**WELWYN HATFIELD BOROUGH COUNCIL
EXECUTIVE DIRECTOR - PLANNING, PUBLIC PROTECTION AND GOVERNANCE**

DELEGATED APPLICATION

Application No: 6/2019/2208/EM
Location: 177 Parkway Welwyn Garden City AL8 6JA
Proposal: Extension of existing driveway
Officer: Mr James Homer

Recommendation: Refused

Drawing No : **4794-P01** Revision: **C**

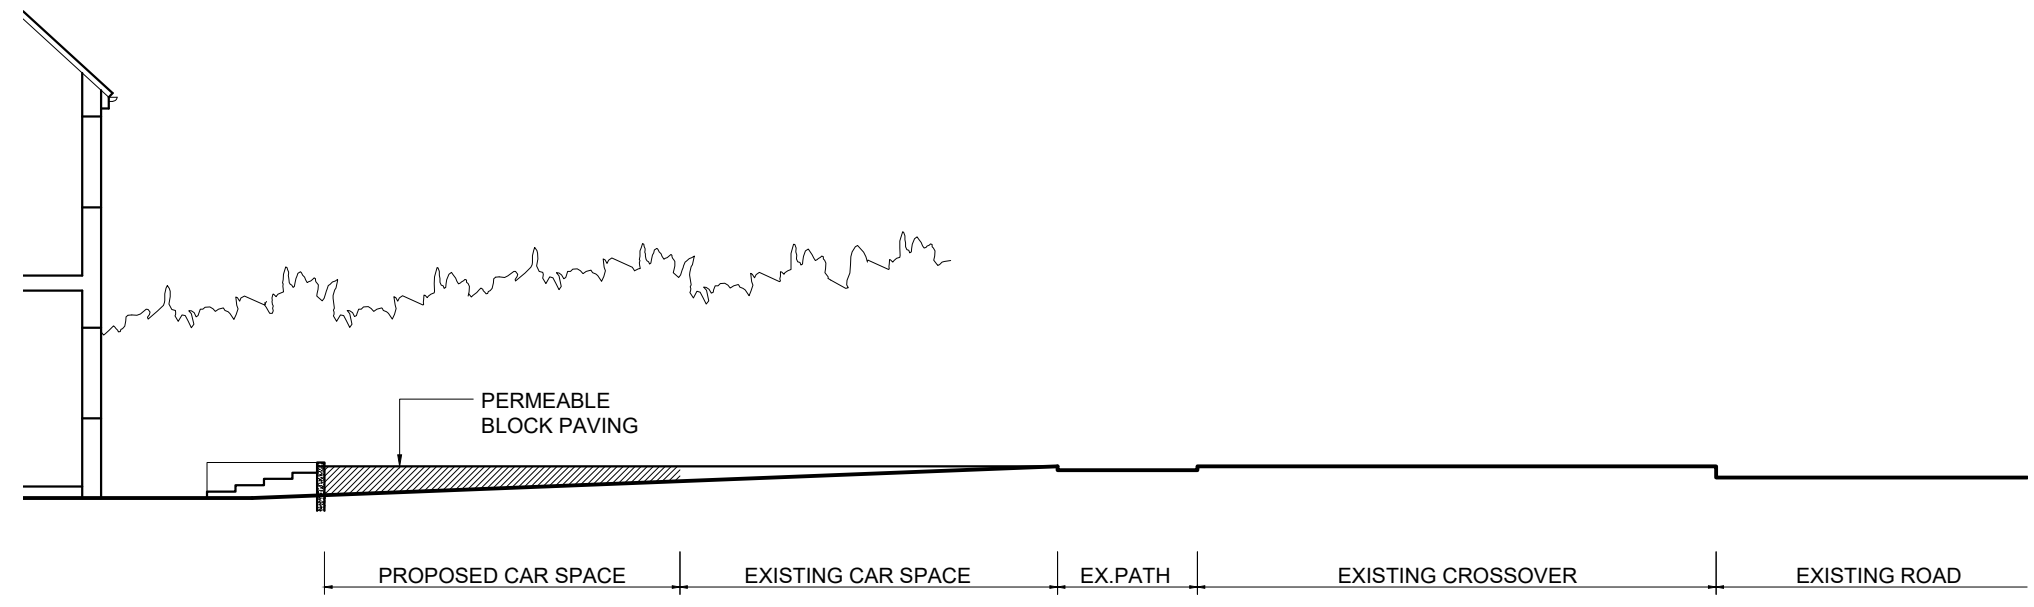
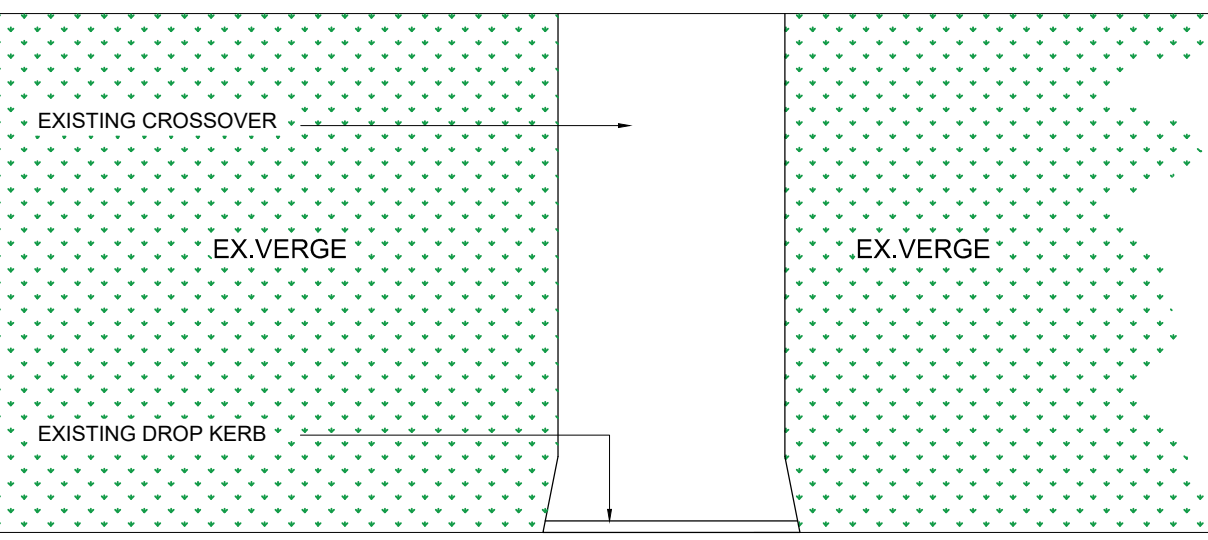
The front garden has an approx. area of 62m². At present, hardstanding covers approx. 29m² which represents 47% coverage and includes a footpath which was not part of the application previously approved (W6/2010/1276/EM). This application would see the area of hardstanding extended further into the front garden resulting in approx. 34m² of the front garden being hard landscaped, approx. 54%. In addition to the increase in size, the application proposes to raise the height of the hardstanding so that it is level with the existing hardstanding, rather than follow the natural slope of the garden. The elevation drawing does not show what the height of the raised driveway will be but does include the addition of steps from the front of the property to access the driveway. From visiting the site it would clearly be a significant increase. The surface of the driveway would be permeable block paving, however, no detail has been provided regarding how the raised area will be constructed or how the rest of the front garden will relate to the raised hardstanding.

Although the amount of hardstanding may be considered acceptable due to the restricted parking along Parkway, the proposal to raise the driveway would result in a change in land levels which would be inconsistent with surrounding properties. This is considered an incongruous addition to the front of the property and would have a harmful effect on the character and appearance of the street scene and the wider amenities and values of the area. Once a vehicle is parked on the driveway it would particularly effect the amenity of the neighbouring properties, as the vehicle would be much closer to the dwelling than at present, and would result in a negative impact on privacy and outlook.

The existing and proposed site plans show hedges running along the edge of the public footpath on Parkway. In reality, these hedges are back from the footpath and are located on the property boundary. The proposed plan shows a section of the right hand side hedge missing, which is on highways land. In addition, the small hedge in the garden of no.177 that runs along the boundary

with no.179 is shown as removed, presumably to be replaced with grass. It is not clear from the proposed plan if the hedges on highways land would be removed. As such they are outside of the curtilage of the property and cannot be considered as part of this application. The hedge on the boundary with no.179 is shown as being removed, which is not considered necessary to accommodate the proposed driveway. Consent to remove hedges is rarely given without sound justification and no justifiable cause has been given within the application.
Impact on neighbours	The proposal would impact upon neighbour amenity in terms of privacy and outlook – see above.
Landscaping issues (incl. hardstandings)	Landscaping issues are discussed above.
Any other considerations	None.
Conclusion	
The proposed alterations to the level of the front garden to accommodate the extended hardstanding would have a harmful effect on the character and appearance of the street scene and the wider amenities and values of the area. The proposal would also effect the amenity of the neighbouring properties which would result in a negative impact on privacy and outlook. In addition, sound justification for the removal of the hedge on the neighbouring boundary has not be given. The application, therefore, does not satisfy the requirements of Policies EM3 and EM4 of the Estate Management Scheme.
